From: [REDACTED]
Sent: 09 August 2026 15:49
To: Planning
Subject: FAO: Anna Robinson URGENT: Additional Material Objection – Application 3/2026/0354 (13 Brookside)

I am writing as the [REDACTED] to submit an important, supplementary material objection regarding planning application **3/2026/0354** for the proposed development at **13 Brookside, Old Langho, BB6 8AP**.

Proposed Site Plan

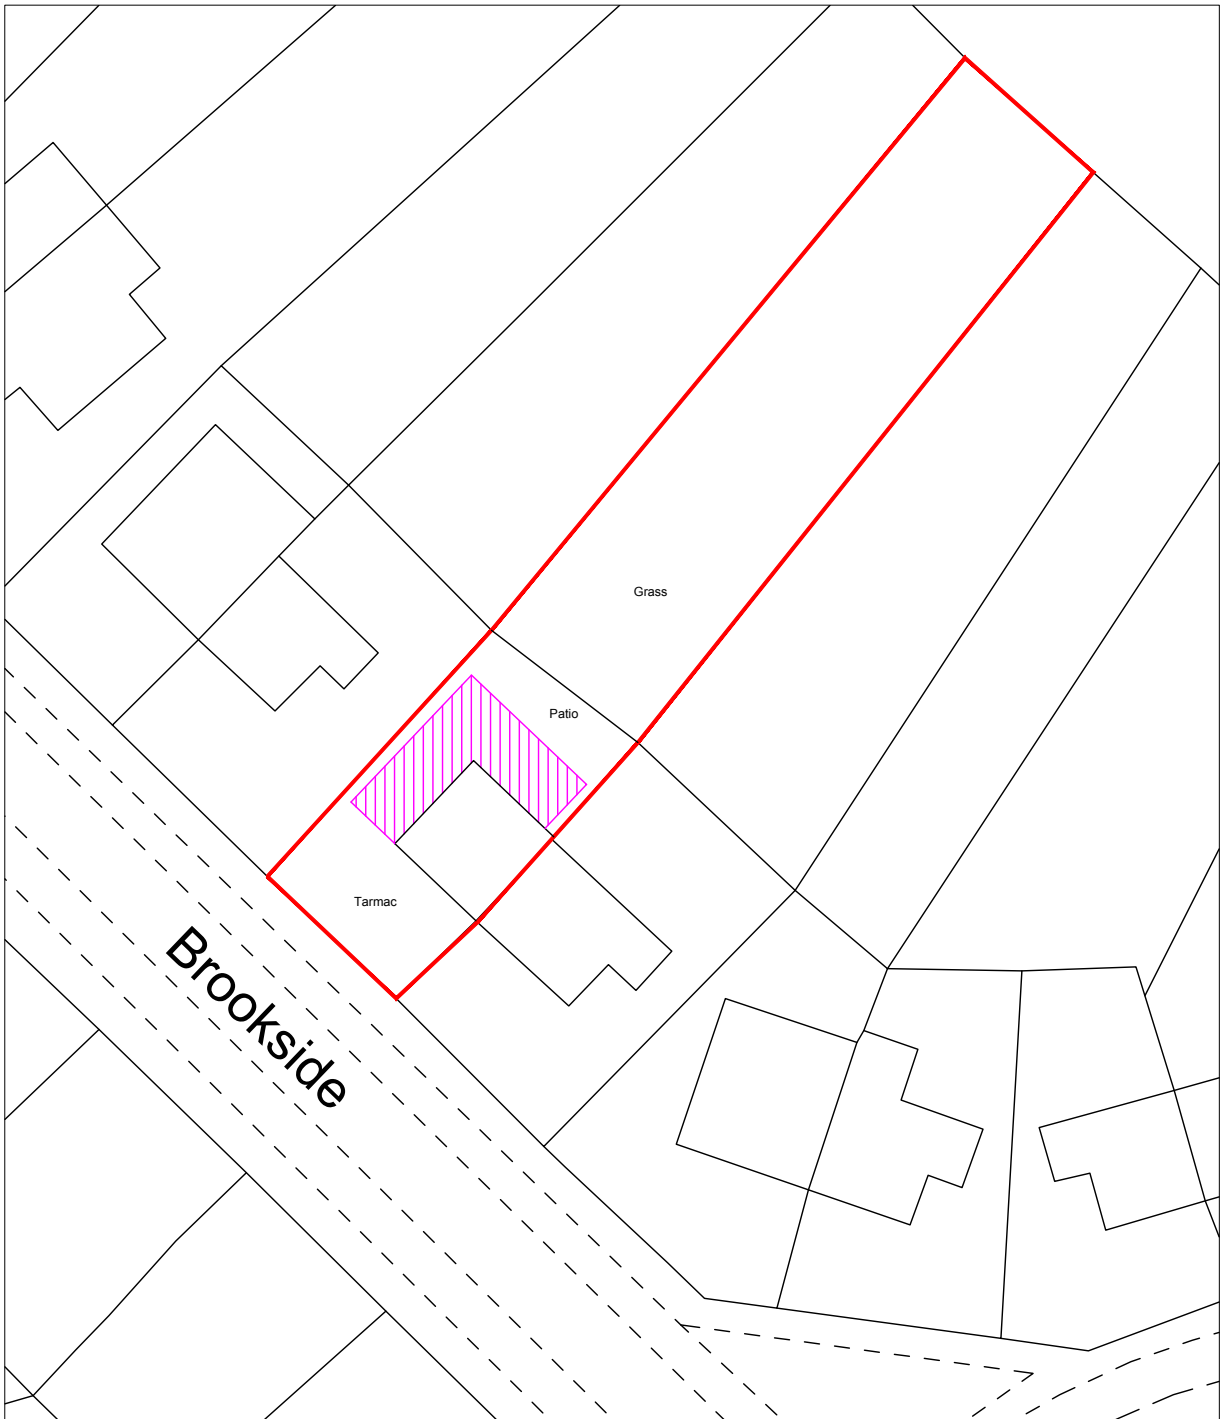
By expanding the property into a large 4-bedroom home, the required off-street parking demand increases under local highways standards. Squeezing **3 car spaces onto the front driveway** is completely unrealistic for this site layout. Because there is no adequate

turning circle on the driveway, vehicles will be forced to reverse blindly out onto a narrow residential street or execute dangerous multi-point turns in the road. This creates an unacceptable highway safety hazard on a narrow residential road heavily utilized by residents, delivery vans, and emergency services.

Client	Liam Wilson		
Project	13 Brookside, Old Langho 2 Storey Side Extension		
Drawing	Scheme 1 - plans & elevations		
Date	Drawn by	Scales	
April 2026	MJ	1:50	@ A1
Job No - Dwg No - Rev	HA26008 - SK1 - C

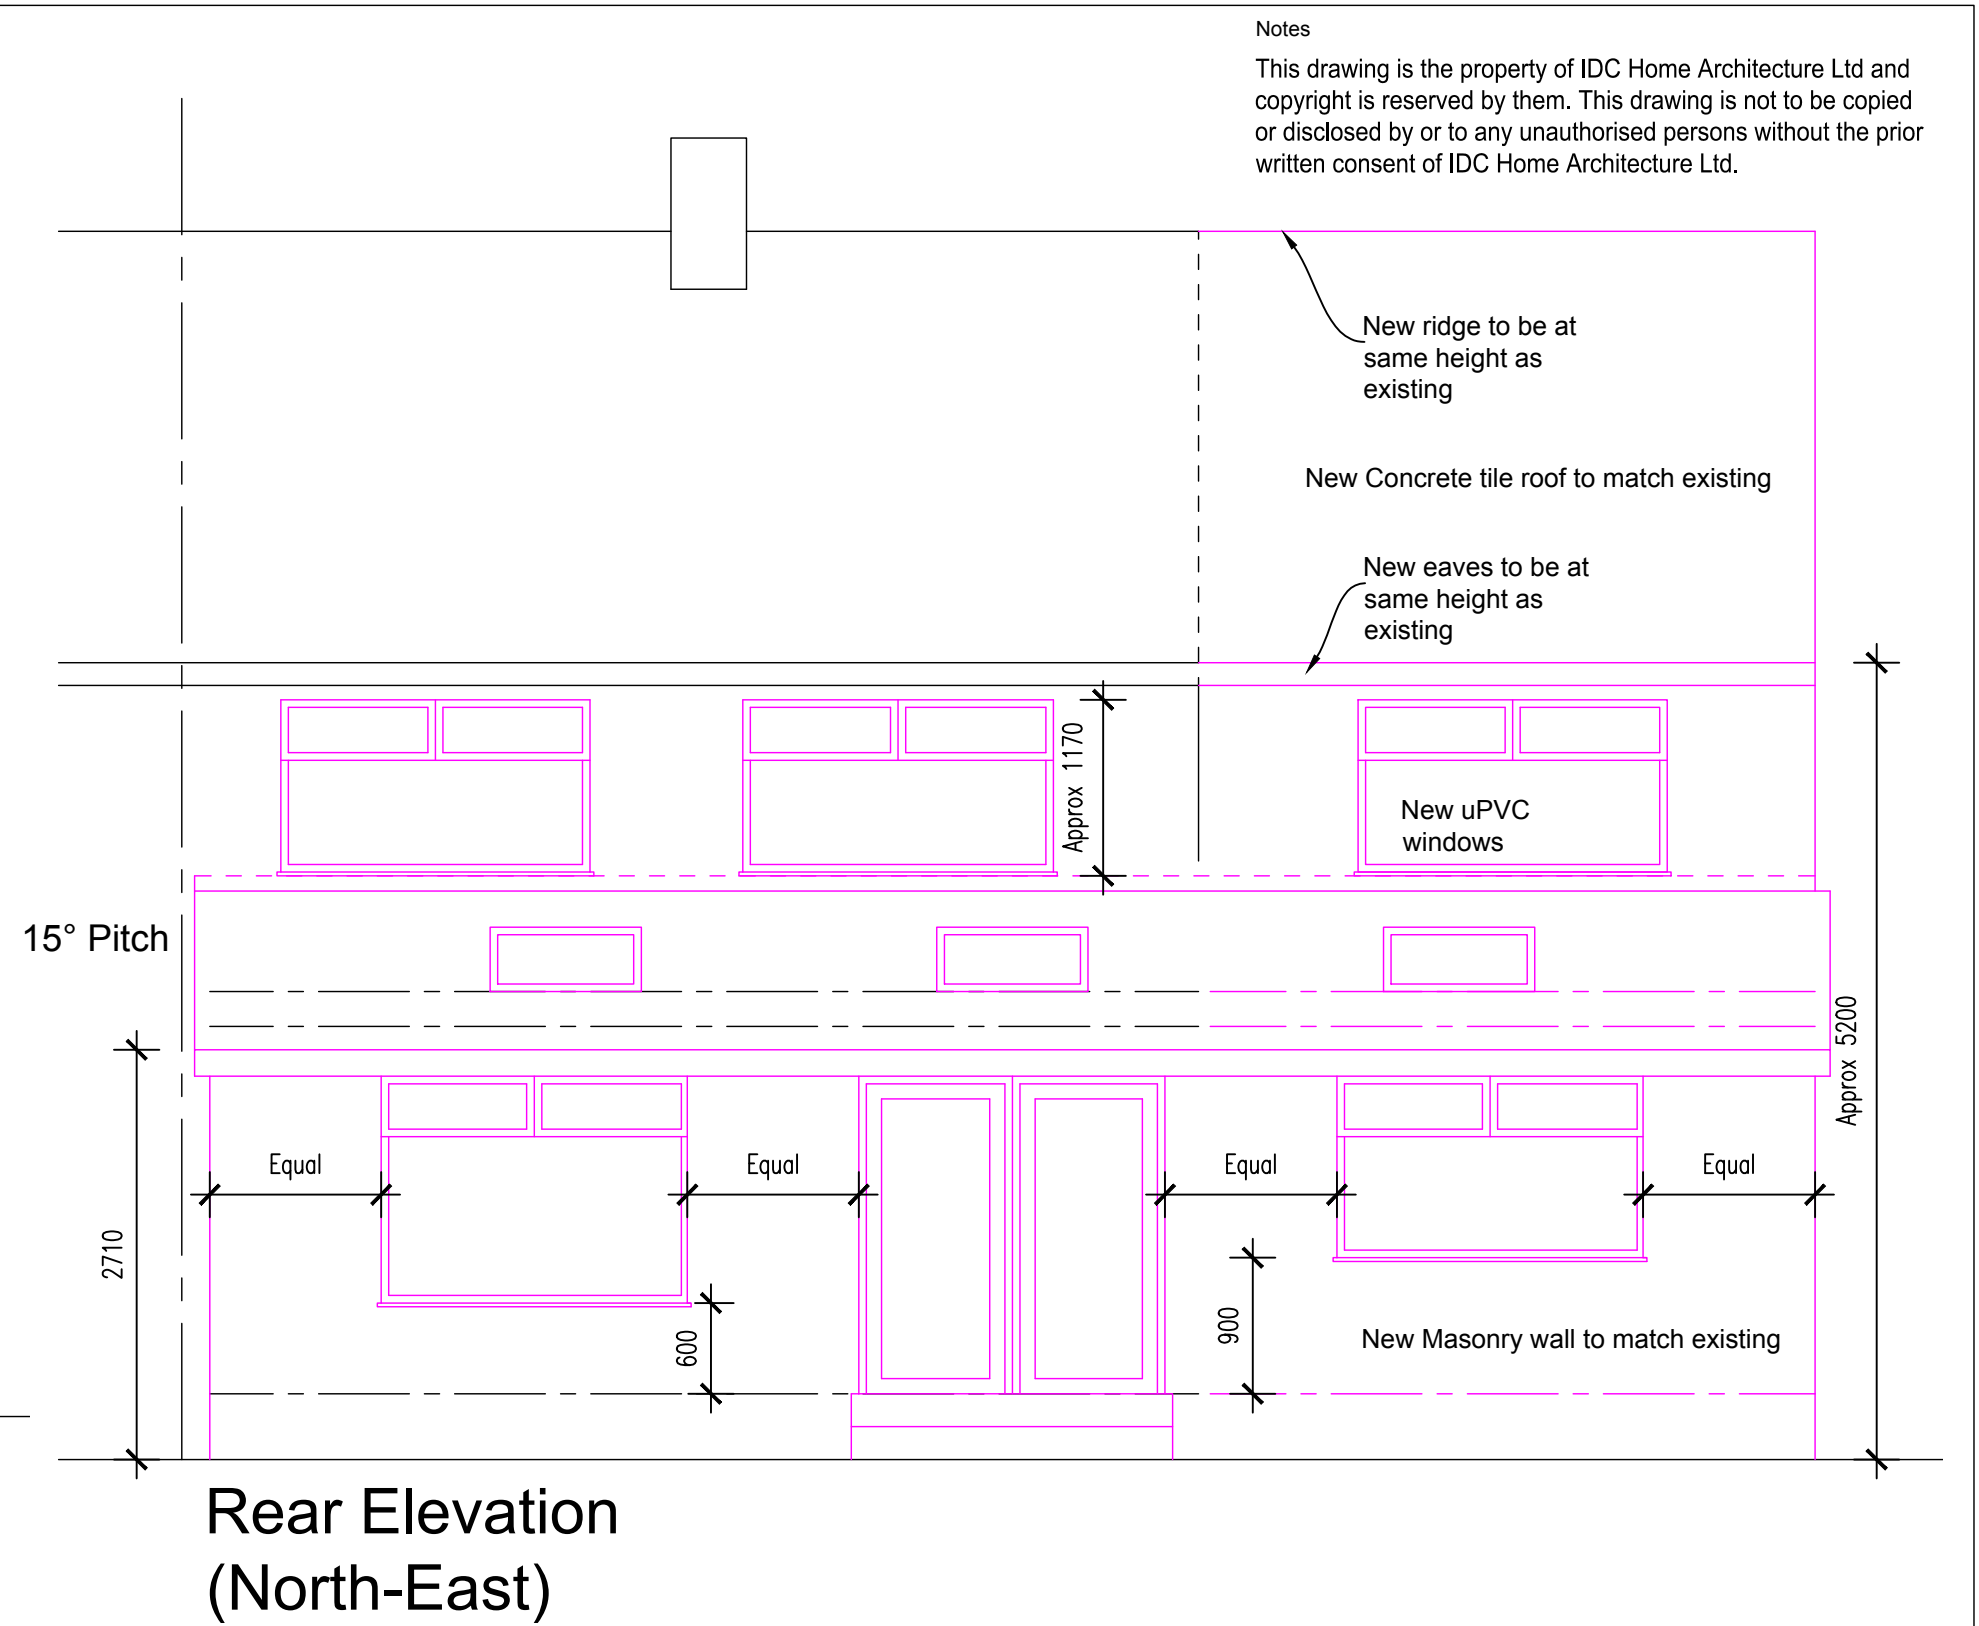
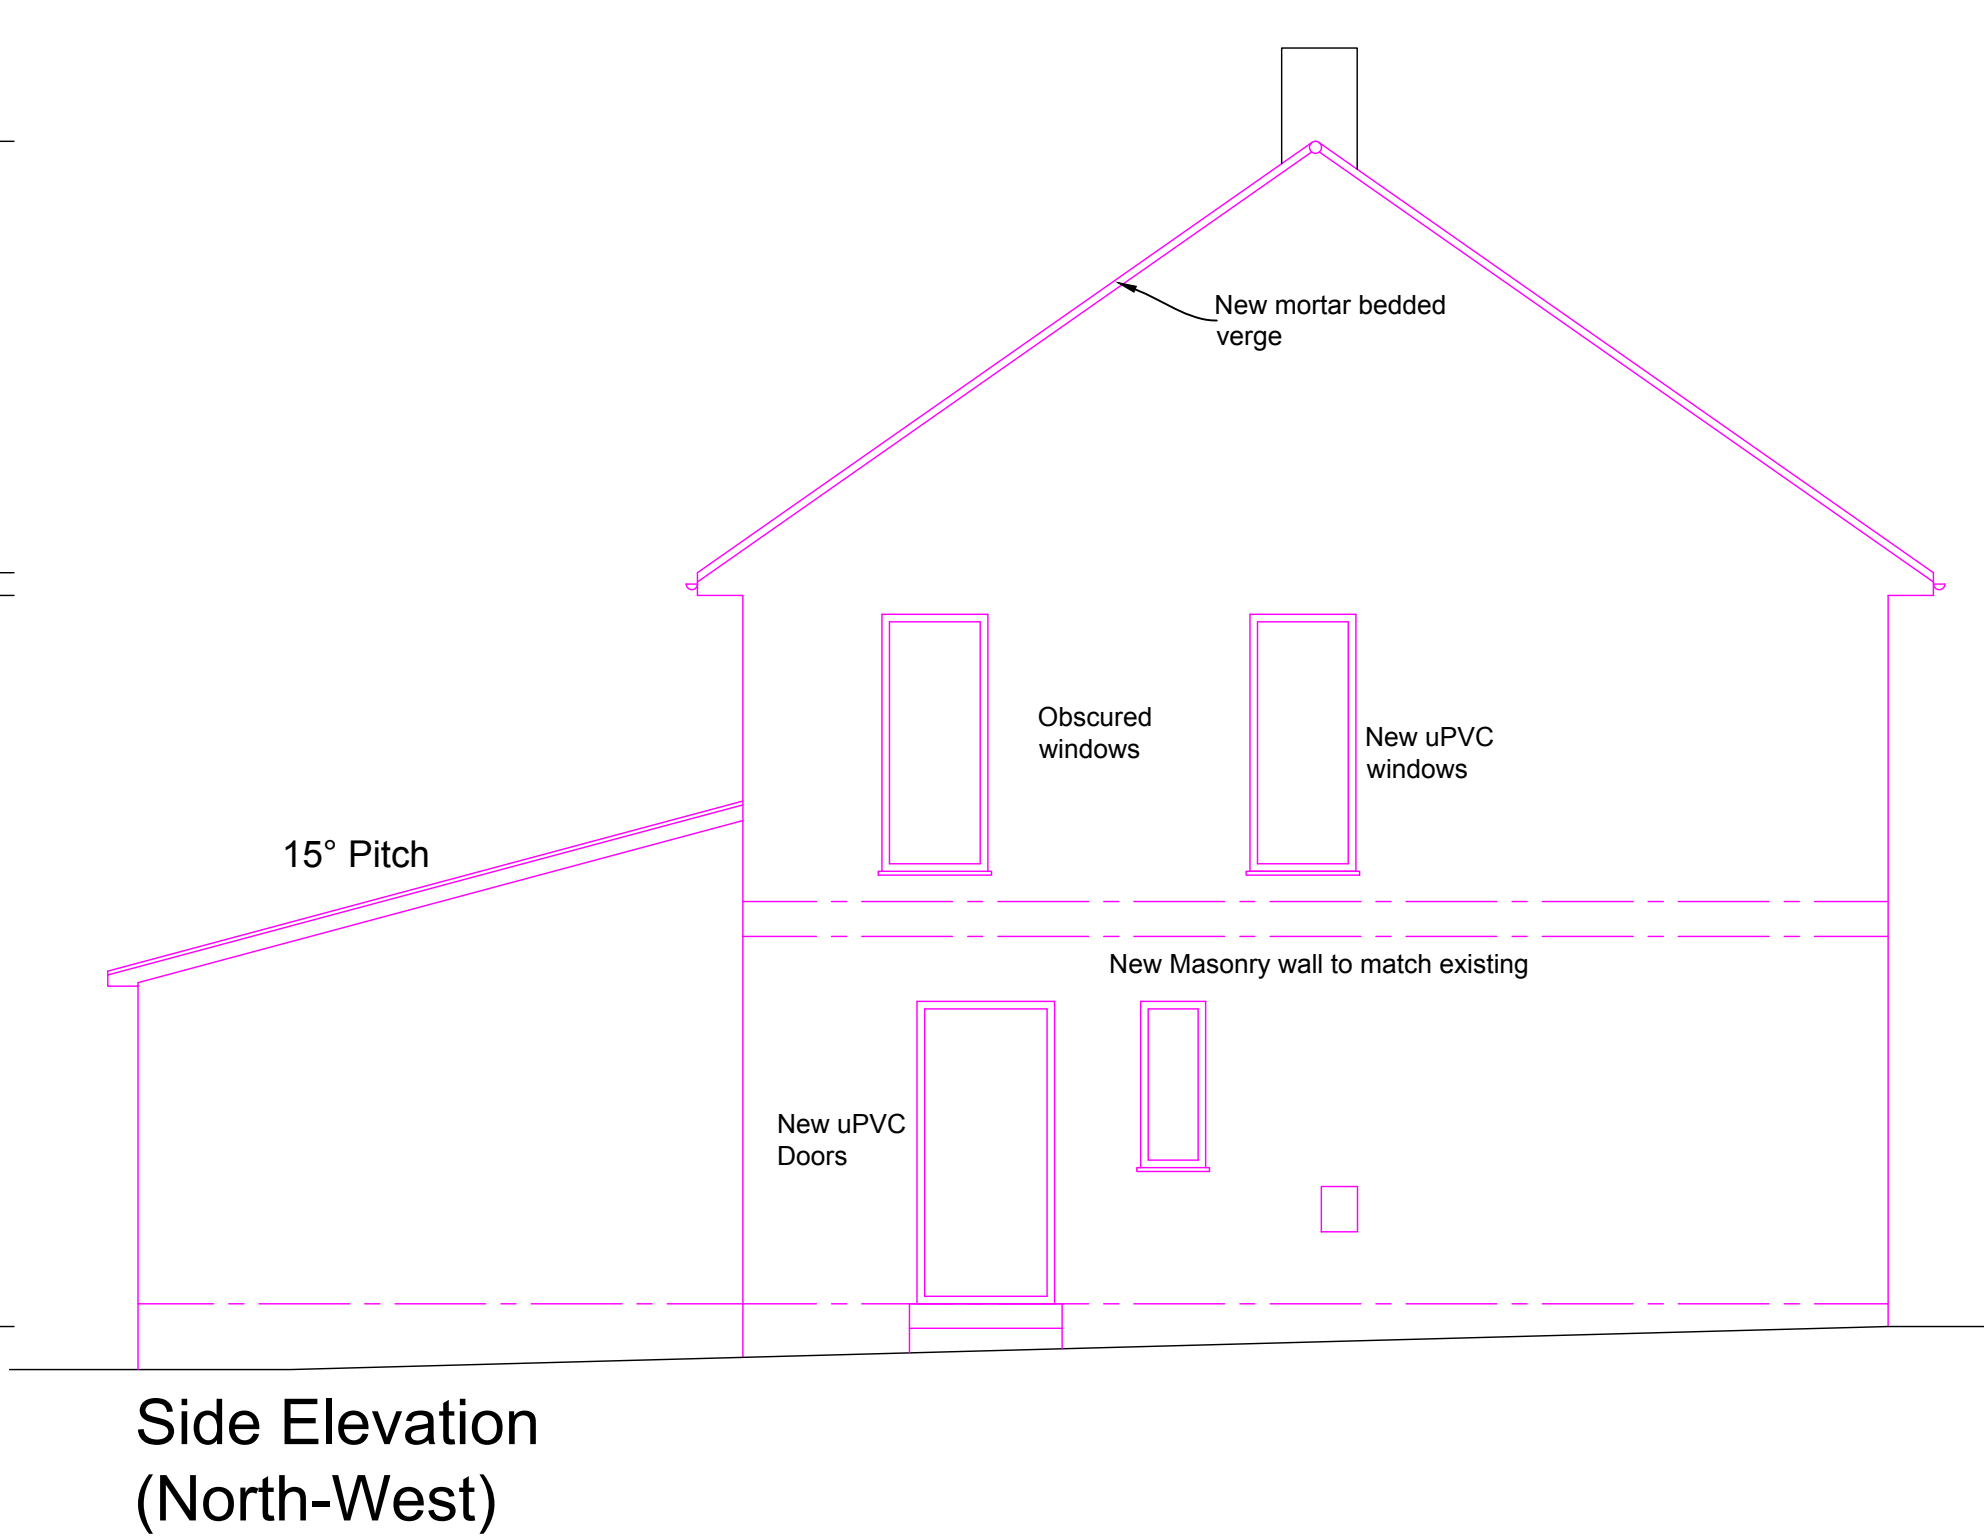
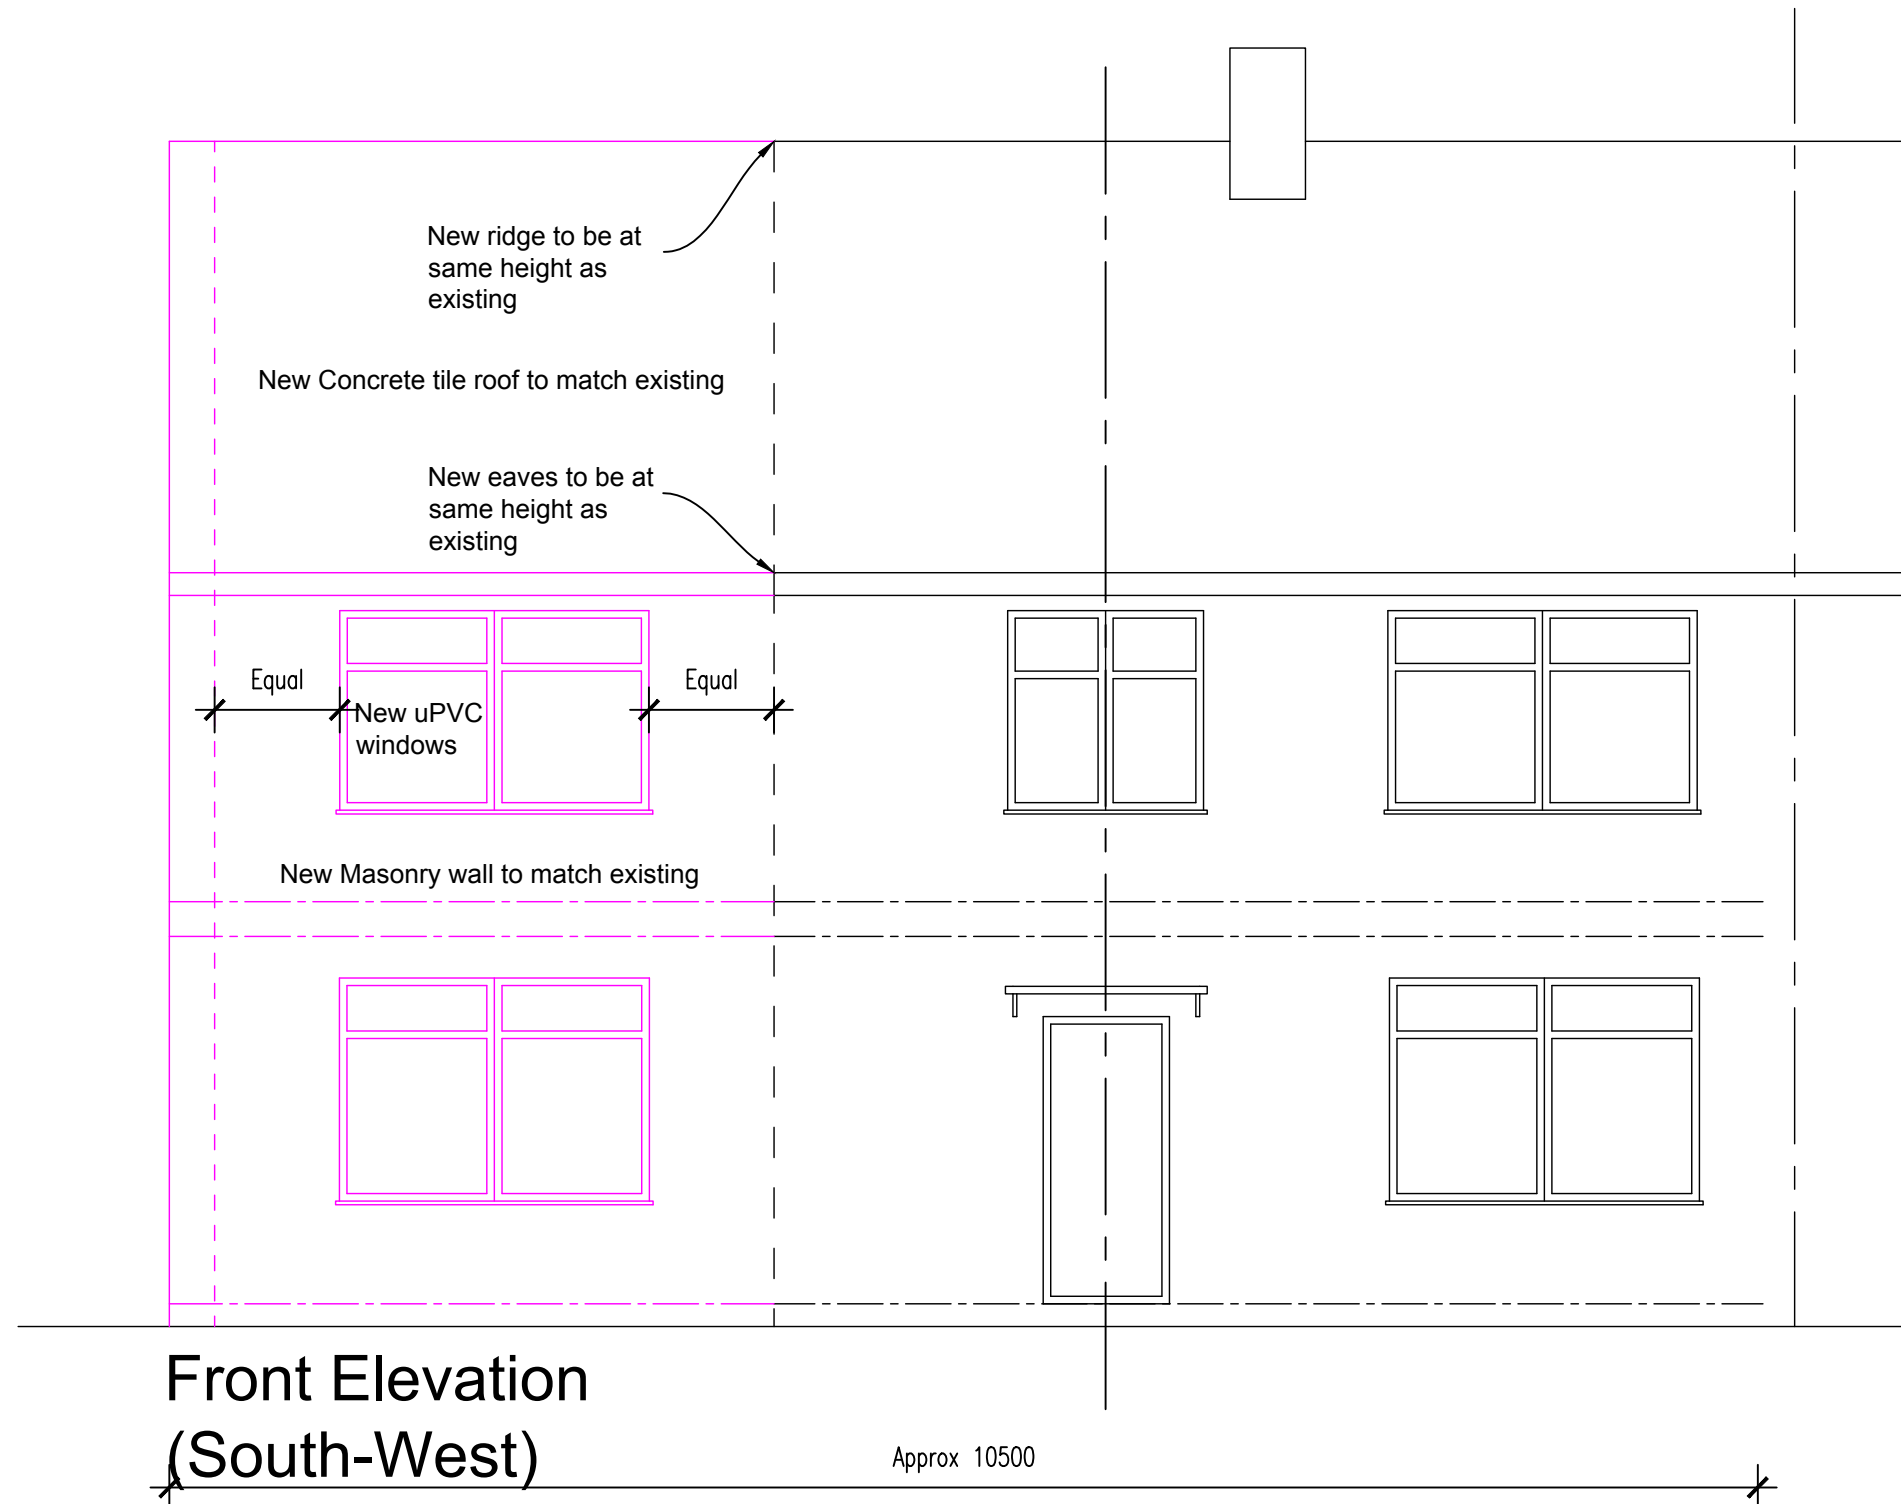
The proposed demolition of the side structure to make way for a substantial two-storey side extension and single-storey rear extension represents a severe overdevelopment of the plot. The scale and massing of this construction will significantly erode the existing sense of openness on the street. It introduces an overly dominant, intrusive, and uncharacteristic form that is too large for the narrow separation distances between properties on Brookside. This layout conflicts directly with **Policy DMG1 of the Ribble Valley Local Plan**, which strictly protects local residential amenity against overbearing structures.

The plans currently reference a first-floor side/front window. Given the narrow distances between the properties, I hold serious concerns regarding the potential for intrusive overlooking if clear glass is permitted in this location. While a non-habitable room window is manageable with strict obscure-glazing conditions, any use of clear-glazed windows in these close proximity zones will create an unacceptable, severe level of direct overlooking into private gardens and habitable windows. If any amended plans or layout adjustments are submitted by the applicant that alter the window treatments, I formally request that the Council triggers a fresh, statutory 14-day re-consultation period.
